Consultation Response from KC, Strategic Housing
2022/93938 First and Second Floors, Shopping Precinct, New Street and Albion Street, Huddersfield, HD1 2TR
Change of use from A1 (business retail and storage) to C3 (residential) 18 studio flats at first and second floors and external alterations
Date Responded: 29/05/2024 Responding Officer: Kate Crozier Responding Ref: SH/22/93928

Proposed Second Floor Plan

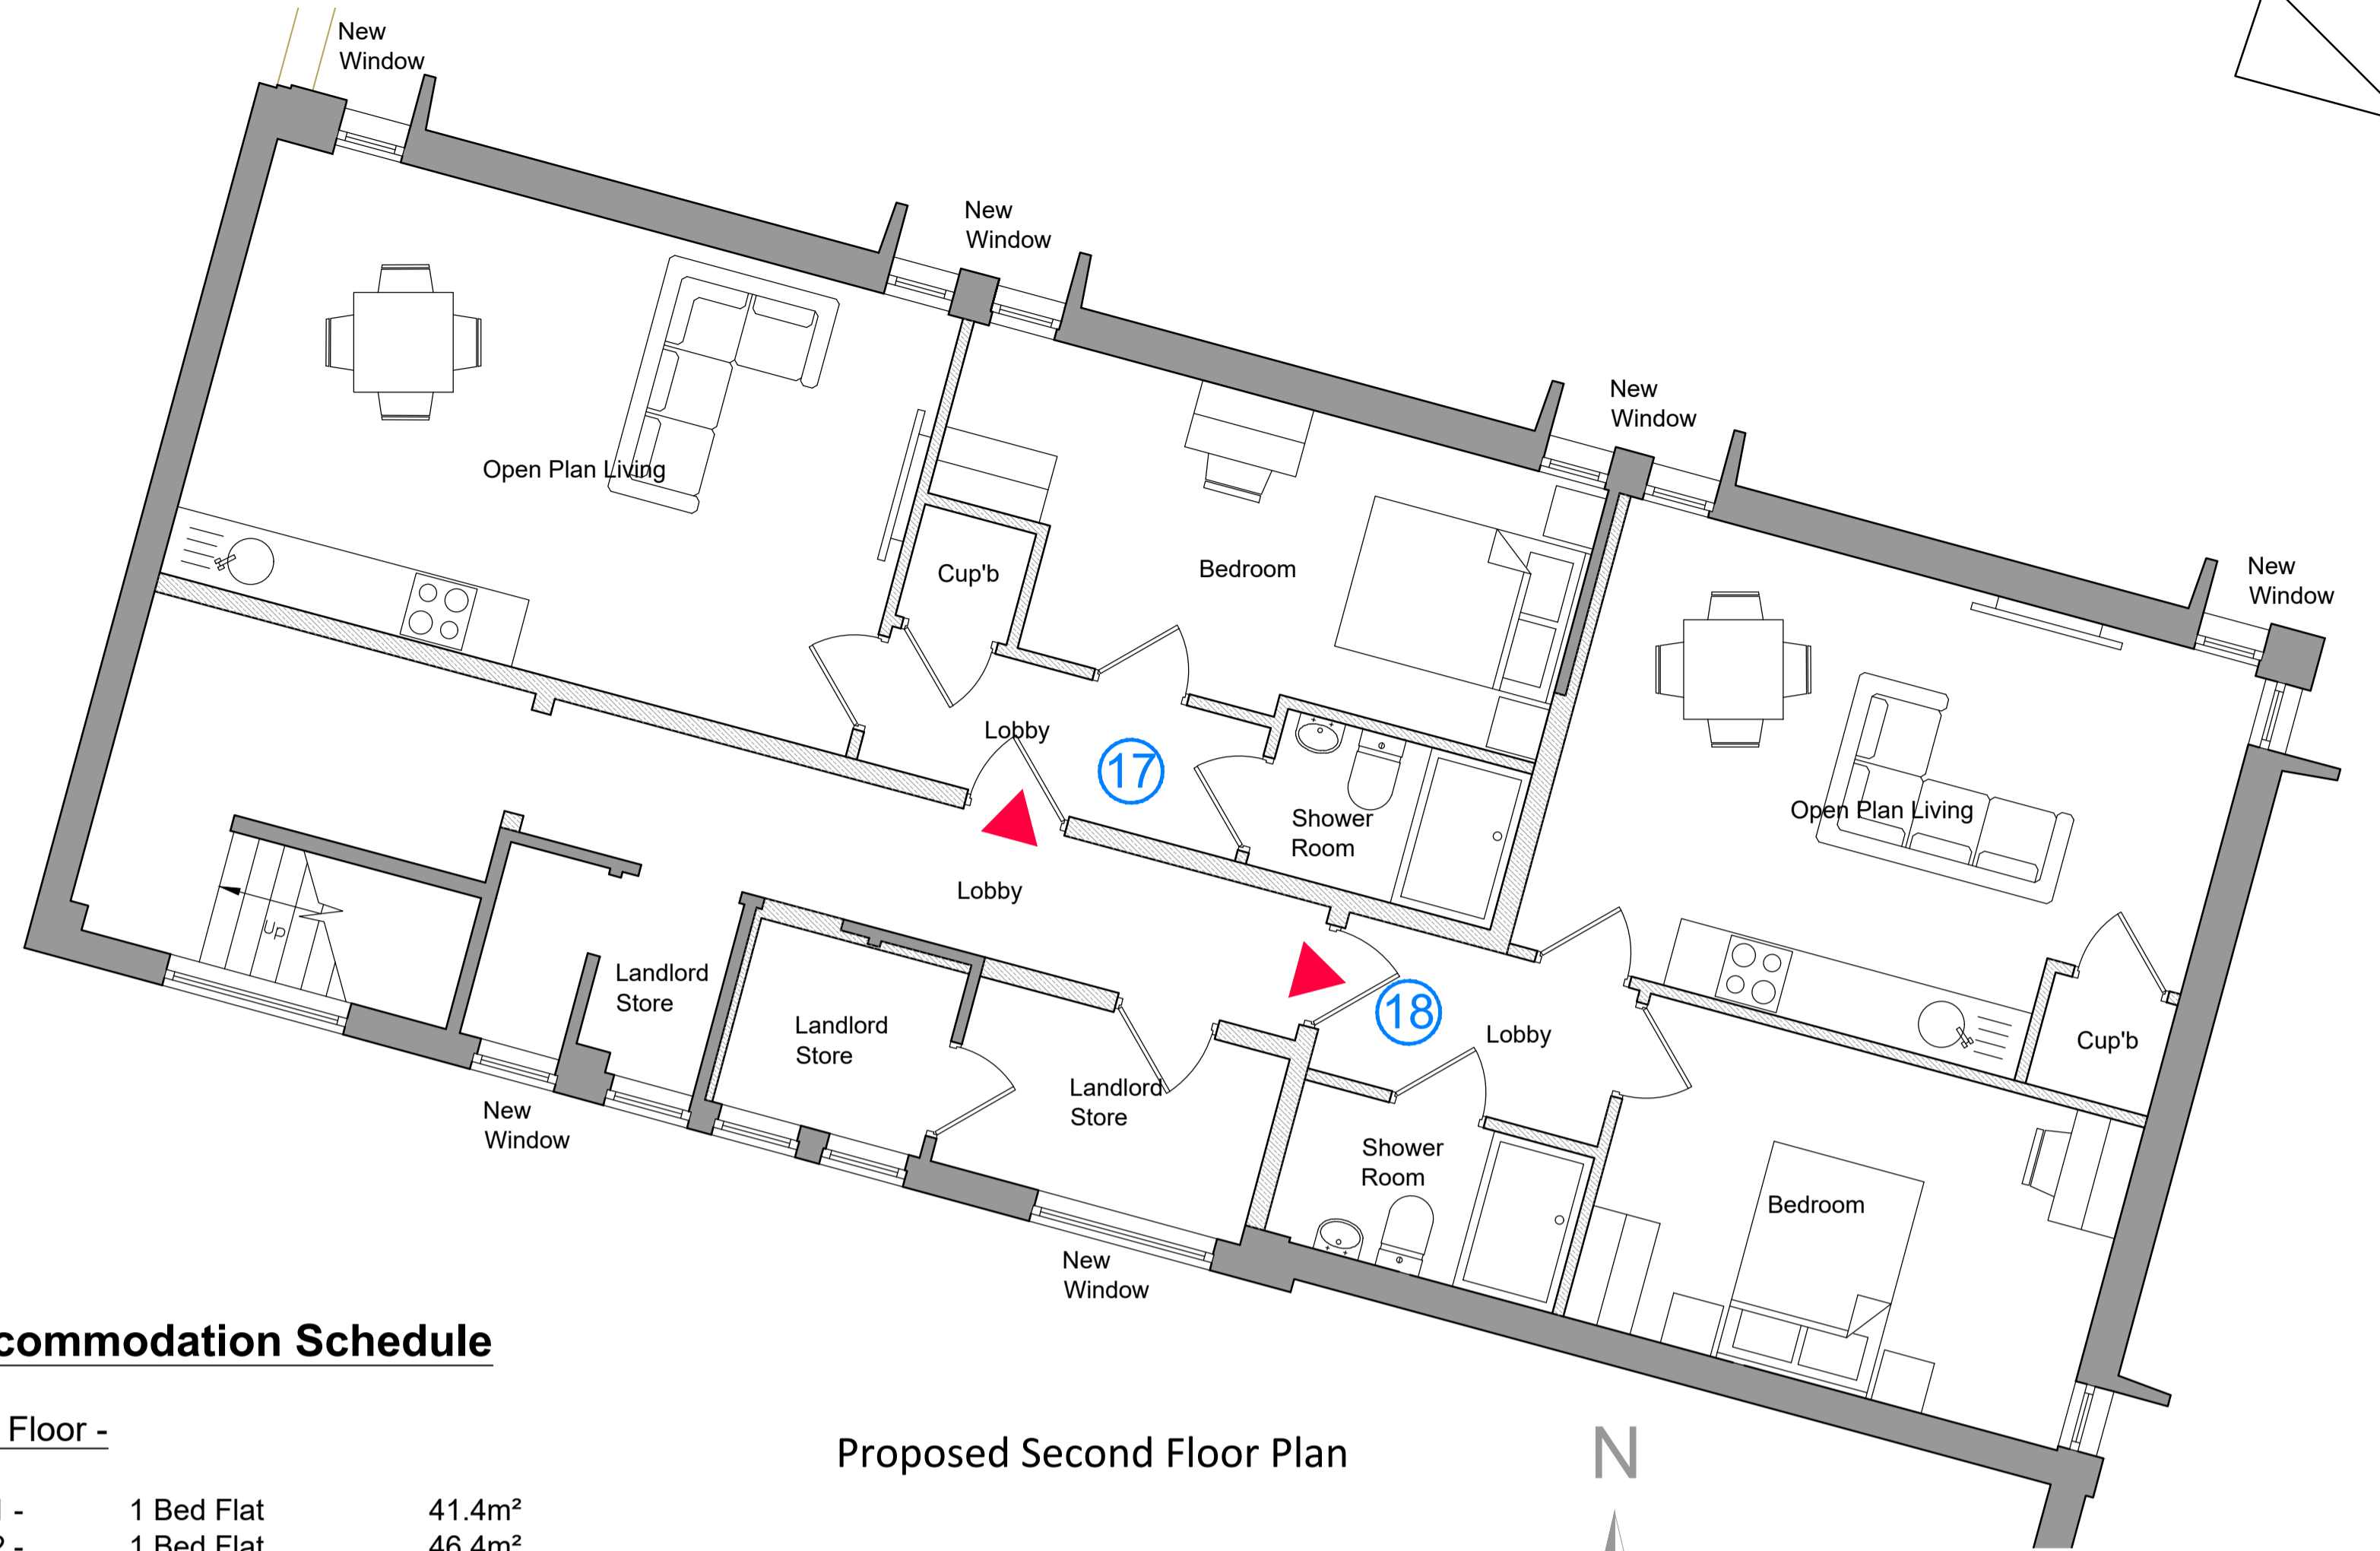
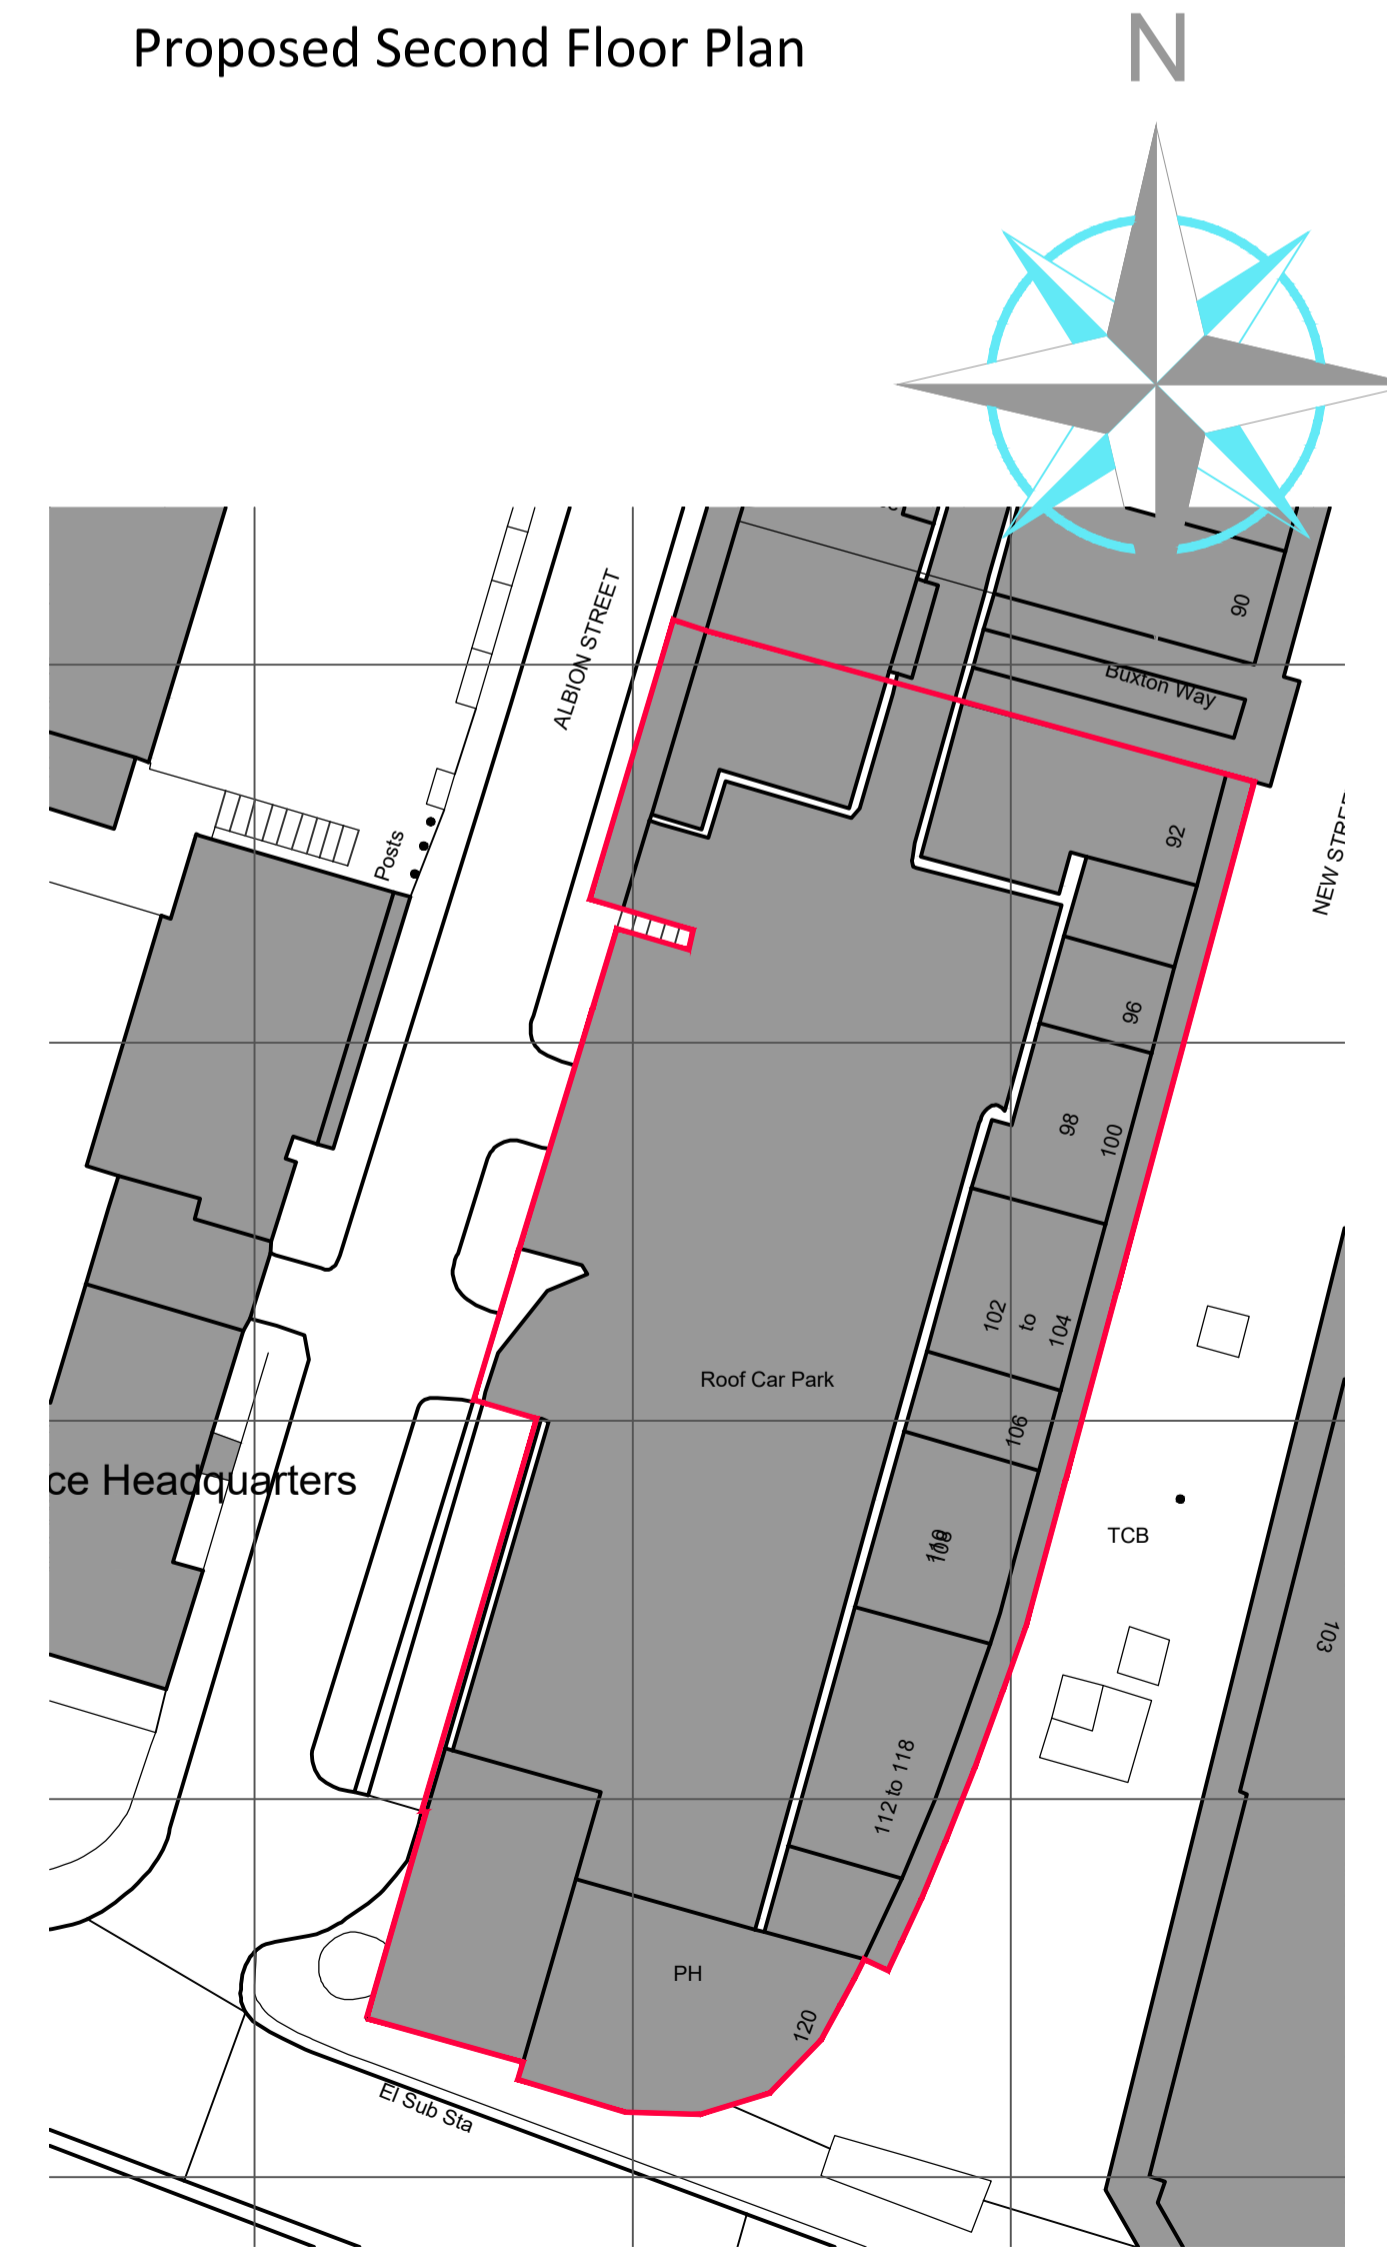
Type: The applicant proposes a mix of 15 x 1 bed flat and 3 x studio flats. This proposal still does not meet the Council's aims to diversify the housing mix in Huddersfield Town Centre by providing a mixture of housing type. A more appropriate provision would be a mix of 1 and 2-bed properties.
